Addendum #5

**The Parkside Neighborhood Center
and Affordable Housing
Mellen & Grant Streets,
Portland, Maine 04101**

May 3, 2004

**S1.0**

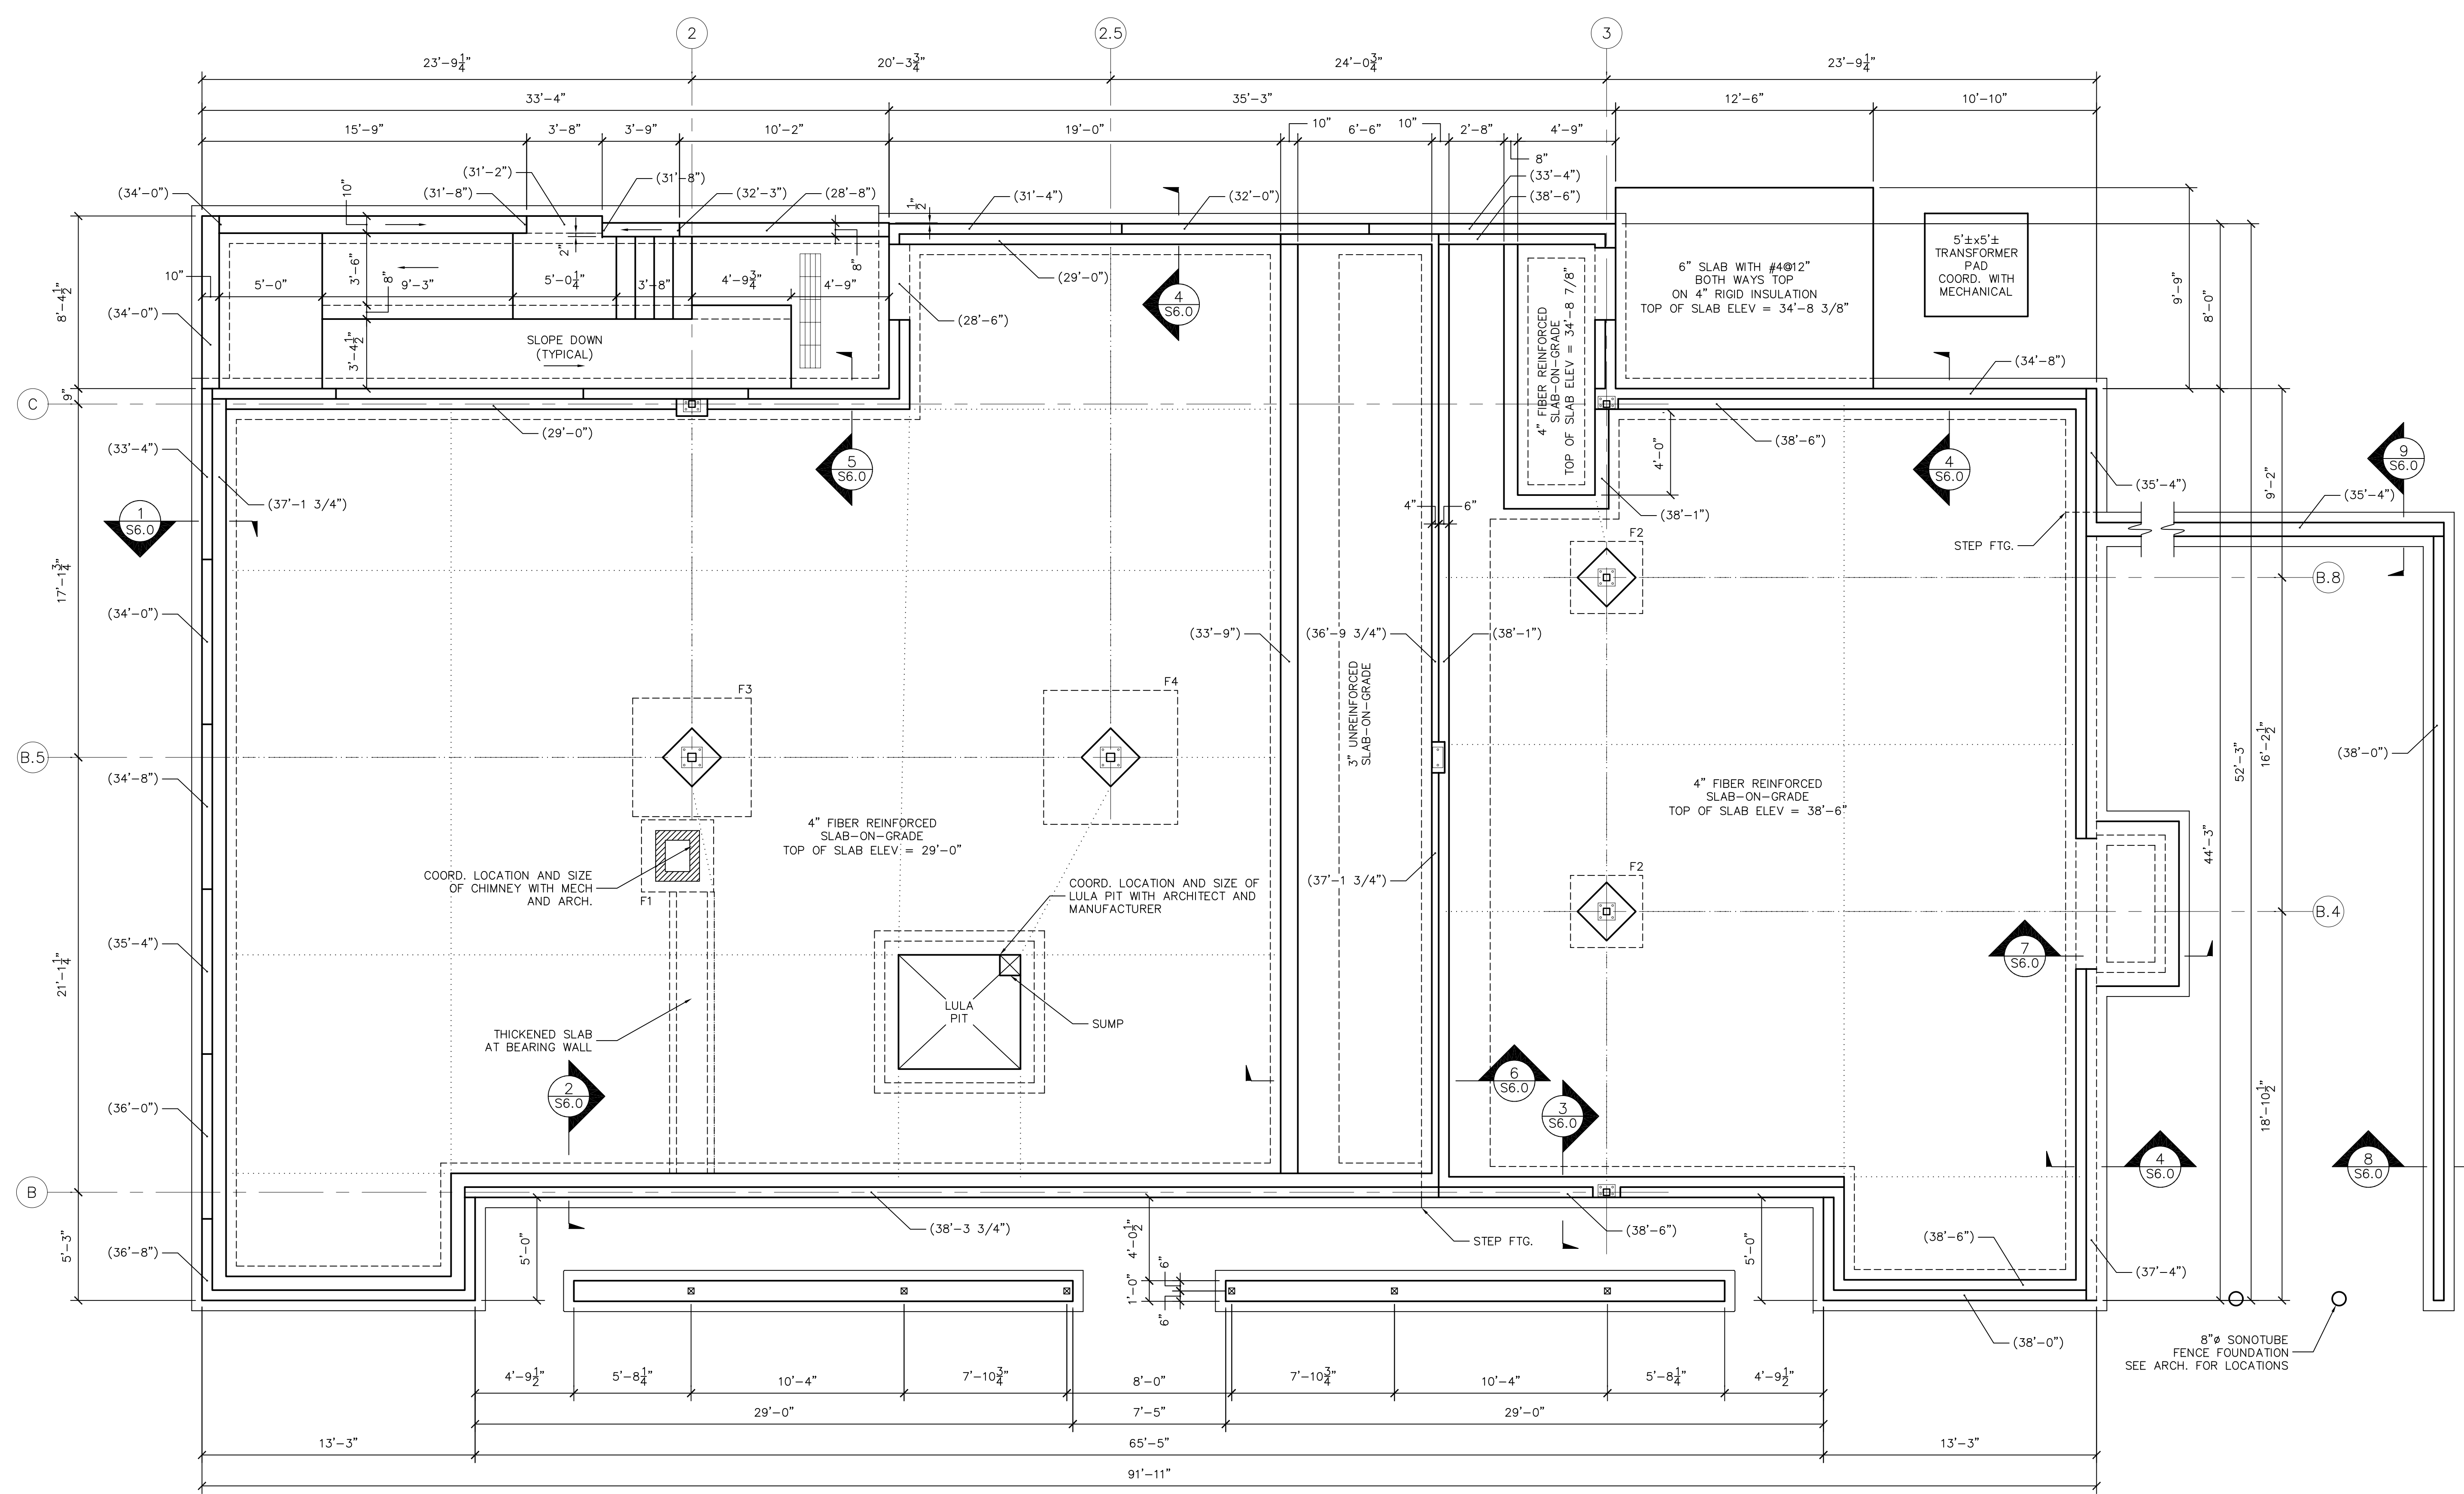
4-49	A S1.0	1	DELETE chimney footing 'F1'. Chimney is deleted and replaced with metal stud and shaftwall per above items.
4-50	A S3.0	1	ADD section designation 6/S7.0-sim west of north porch. 'Sim' designates no brick in section.
4-51	A S4.0	1	REVISE dimension shown at north east corner from 7'-6" 1/2" to 7'-11 1/2".
4-52	A S5.0	1	REVISE dimension shown at north east corner from 7'-6" 1/2" to 7'-11 1/2". ADD note 'See 4/A5.1 Bldg A for porch roof framing'.
4-53	B S1.0	1	DELETE chimney footing 'F1'. Chimney is deleted and replaced with metal stud and shaftwall per above items. REVISE south entrance area as shown on SK9.
4-54	A/B S6.0	1	ADD note 'See Sk7 for stringer sizes.
